<b>Application Ref:</b>	2025/0531			 Ribble Valley Borough Council <small>www.ribblevalley.gov.uk</small>
<b>Date Inspected:</b>	25/07/2025	<b>Site Notice:</b>	25/07/2025	
<b>Officer:</b>	EP			
<b>DELEGATED ITEM FILE REPORT:</b>				<b>REFUSAL</b>

<b>Development Description:</b>	Proposed erection of single-storey dwelling house (self-build) within existing garden curtilage together with new access and hardstanding and demolition of garage.
<b>Site Address/Location:</b>	Land rear of Pendle Street East Sabden BB7 9FX.

Client: **MR & MRS WHITEHURST**  
 Project: **PROPOSED NEW BUILD BUNGALOW**  
**PENDLE STREET EAST, SABDEN**  
 Drawing Title: **PROPOSED SITE PLAN**

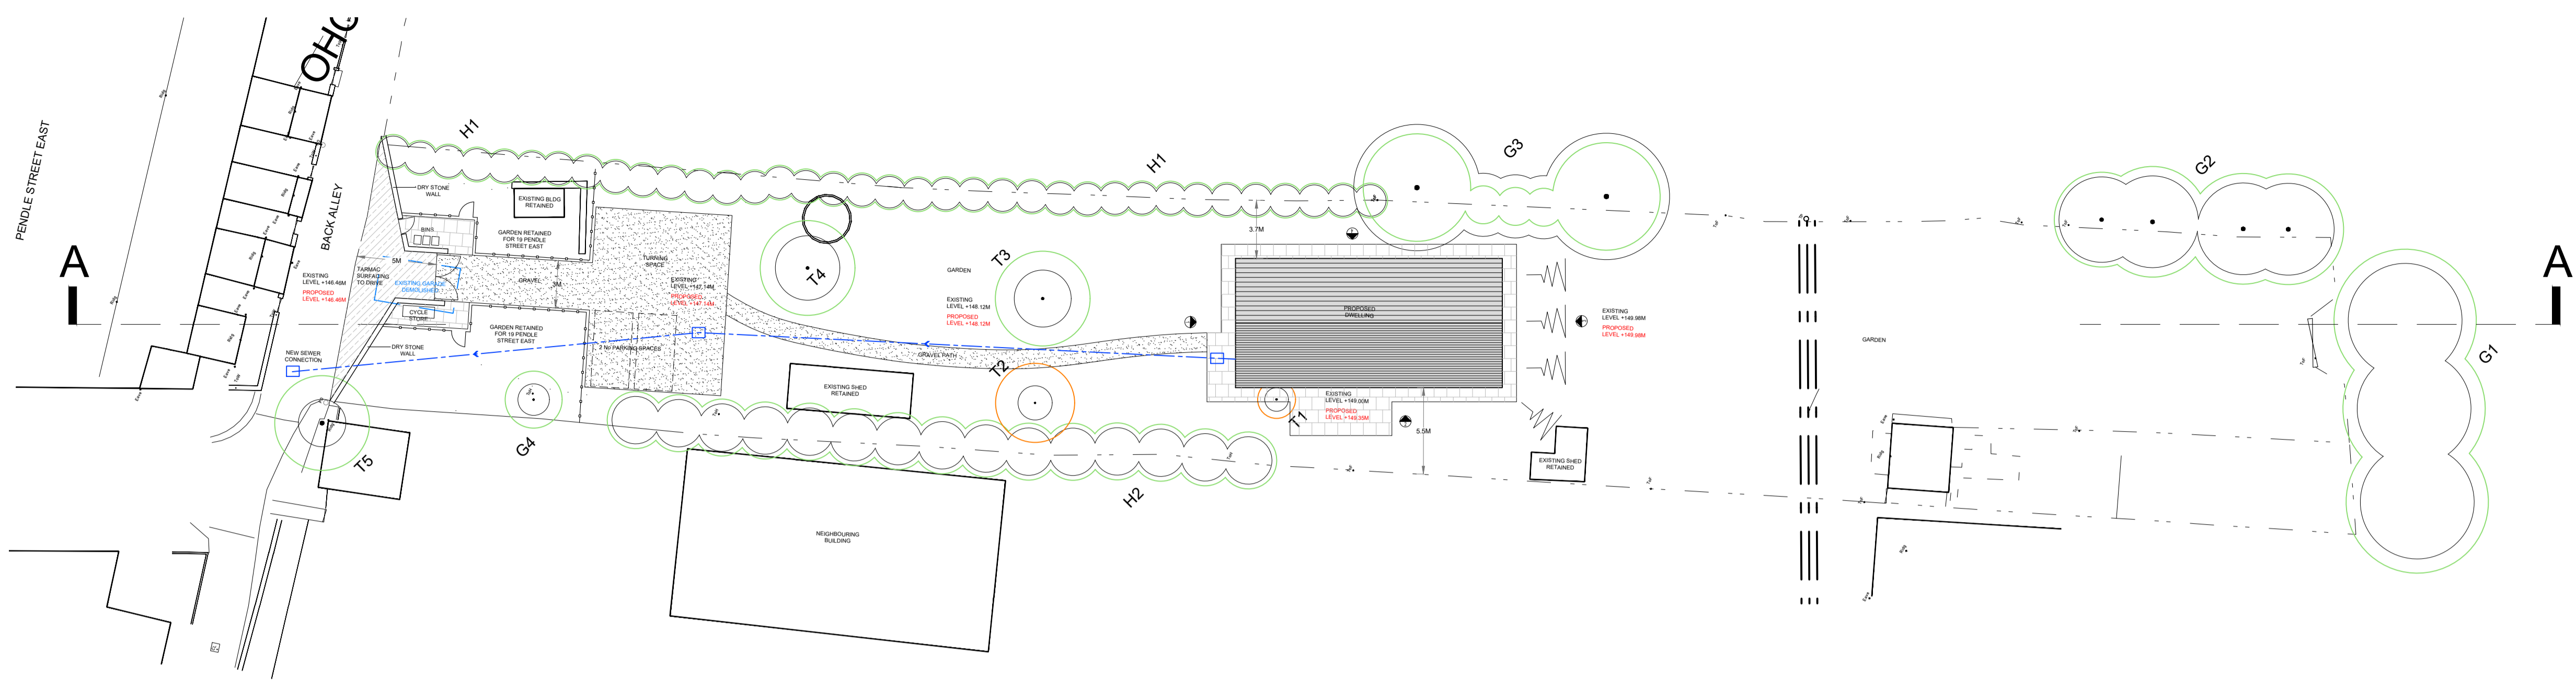
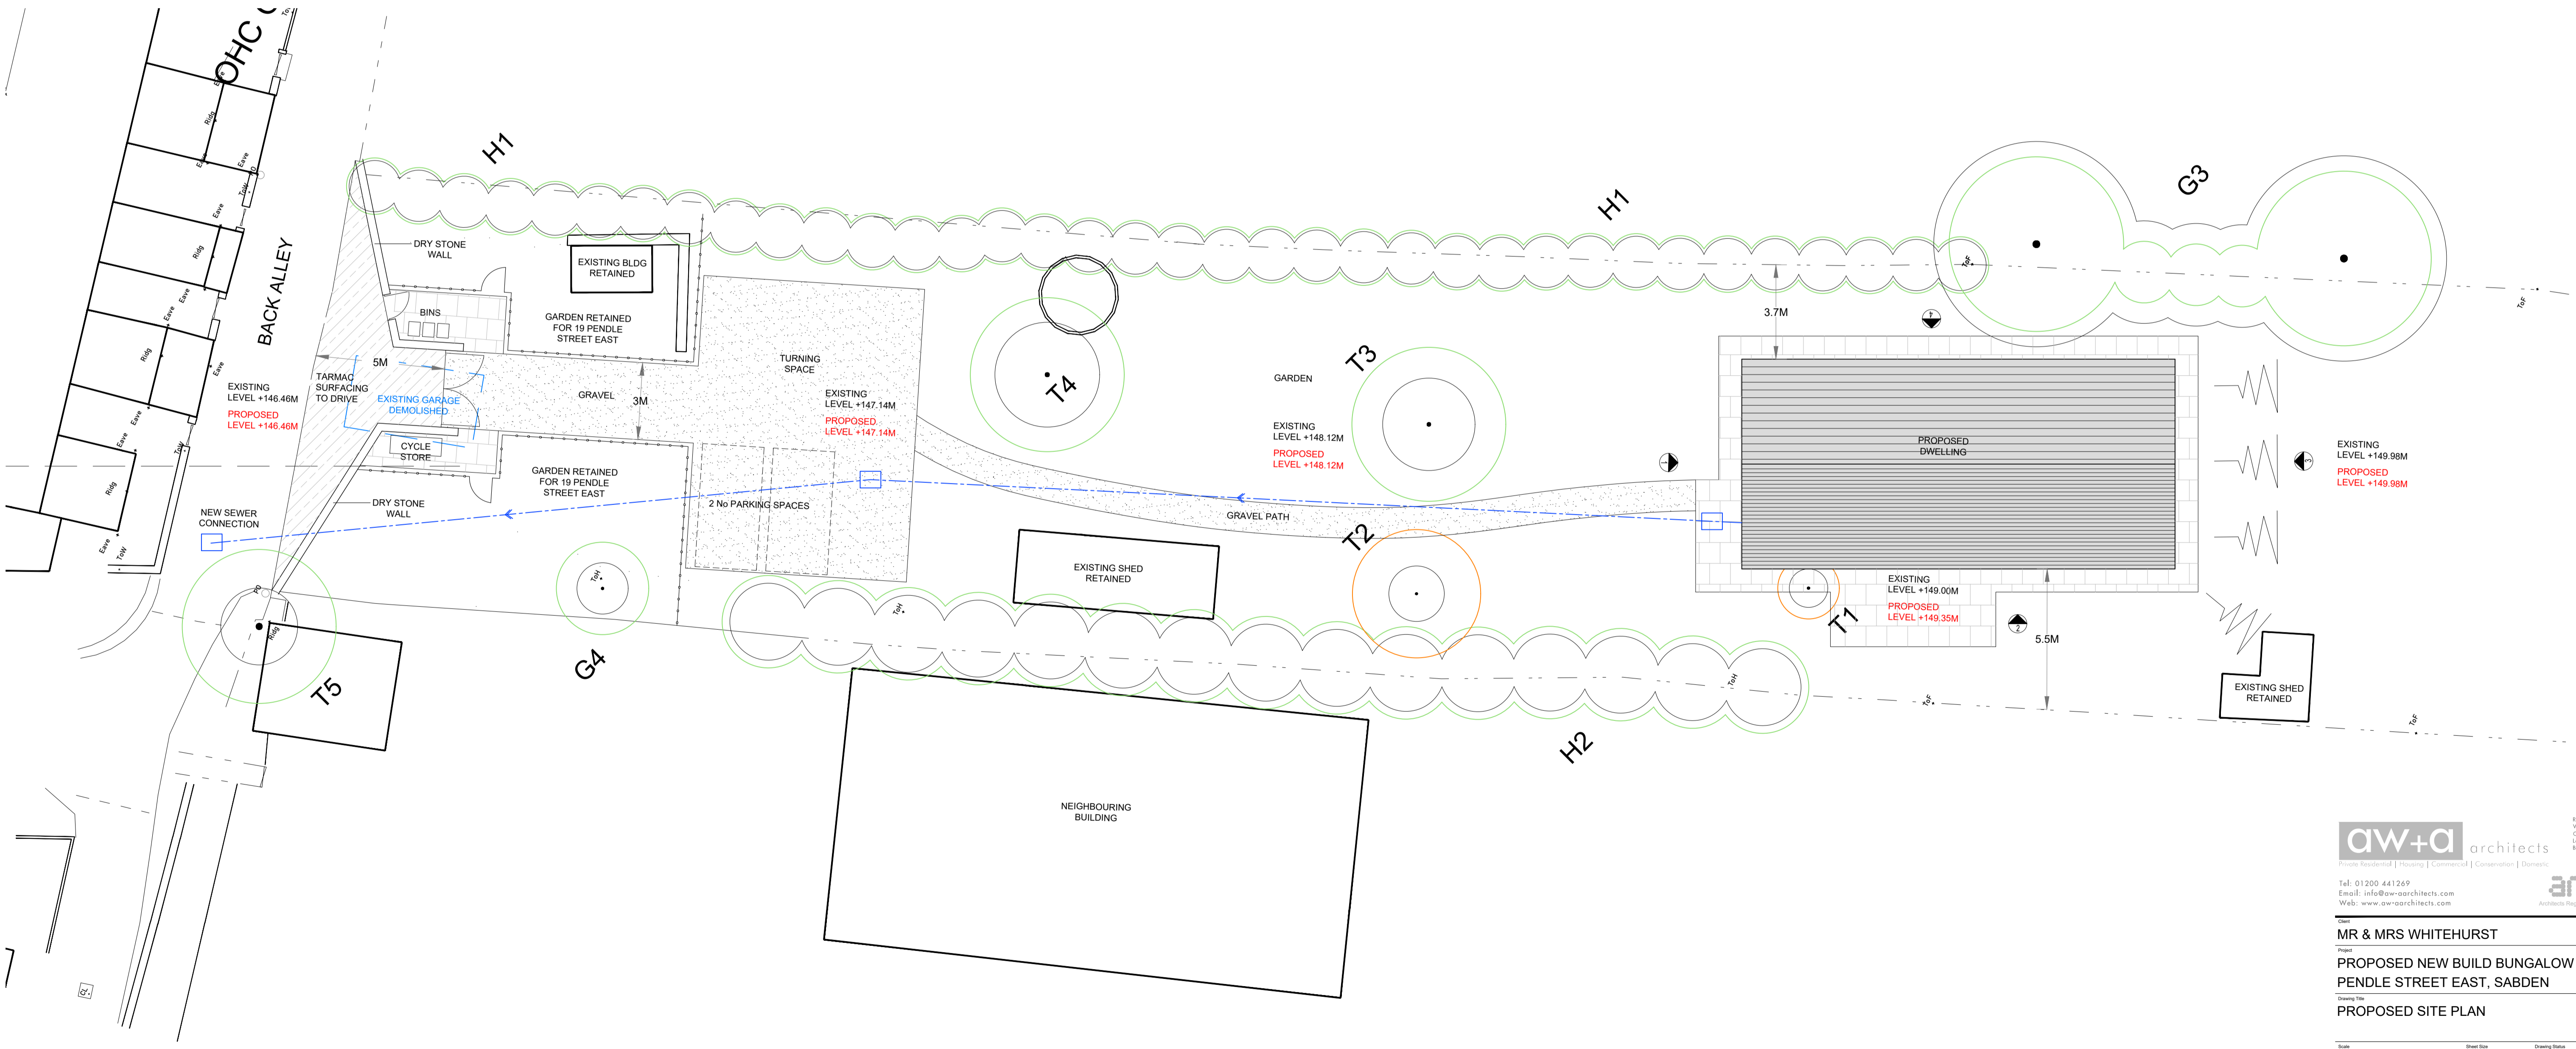
In regard to the proposed siting and layout of the site, the access and parking area will be sited immediately adjacent to the rear of Pendle Street East. At the entrance to the site, a parcel of garden will be retained for 19 Pendle Street East, which the applicants currently own and occupy. The dwelling itself will be accessed via a long garden path, leaving a substantial separation distance between the parking facilities and the dwelling itself. The dwelling itself is located approximately 65 metres from existing residential development. Whilst there are other outbuildings and structures in the vicinity of the site, it is not considered that the proposed site layout and dwelling location corresponds well to existing built development. The distance between the access/parking area and the dwelling itself is excessive and results in the new dwelling taking an unnecessarily isolated position within the site. The applicants cite the current use of the site is residential curtilage but there is no planning history or certificate of lawfulness confirming this. Even if this is confirmed, the proposed development including associated domestic paraphernalia will have an urbanising impact on the site and extend built form further away from the current pattern of development.

The submitted tree survey and proposed site plans outline tree protection and removal measured required to accommodate the development. Two trees are proposed for removal; these are labelled as T1 and T2 within the submitted survey and are identified as being of moderate quality are early-mature/semi0mature. It is not considered that these trees, given their quality, age and location, are of significant visual amenity value and therefore their removal would not cause concern subject to a scheme for replacement planting being agreed. This could be achieved via suitable condition.
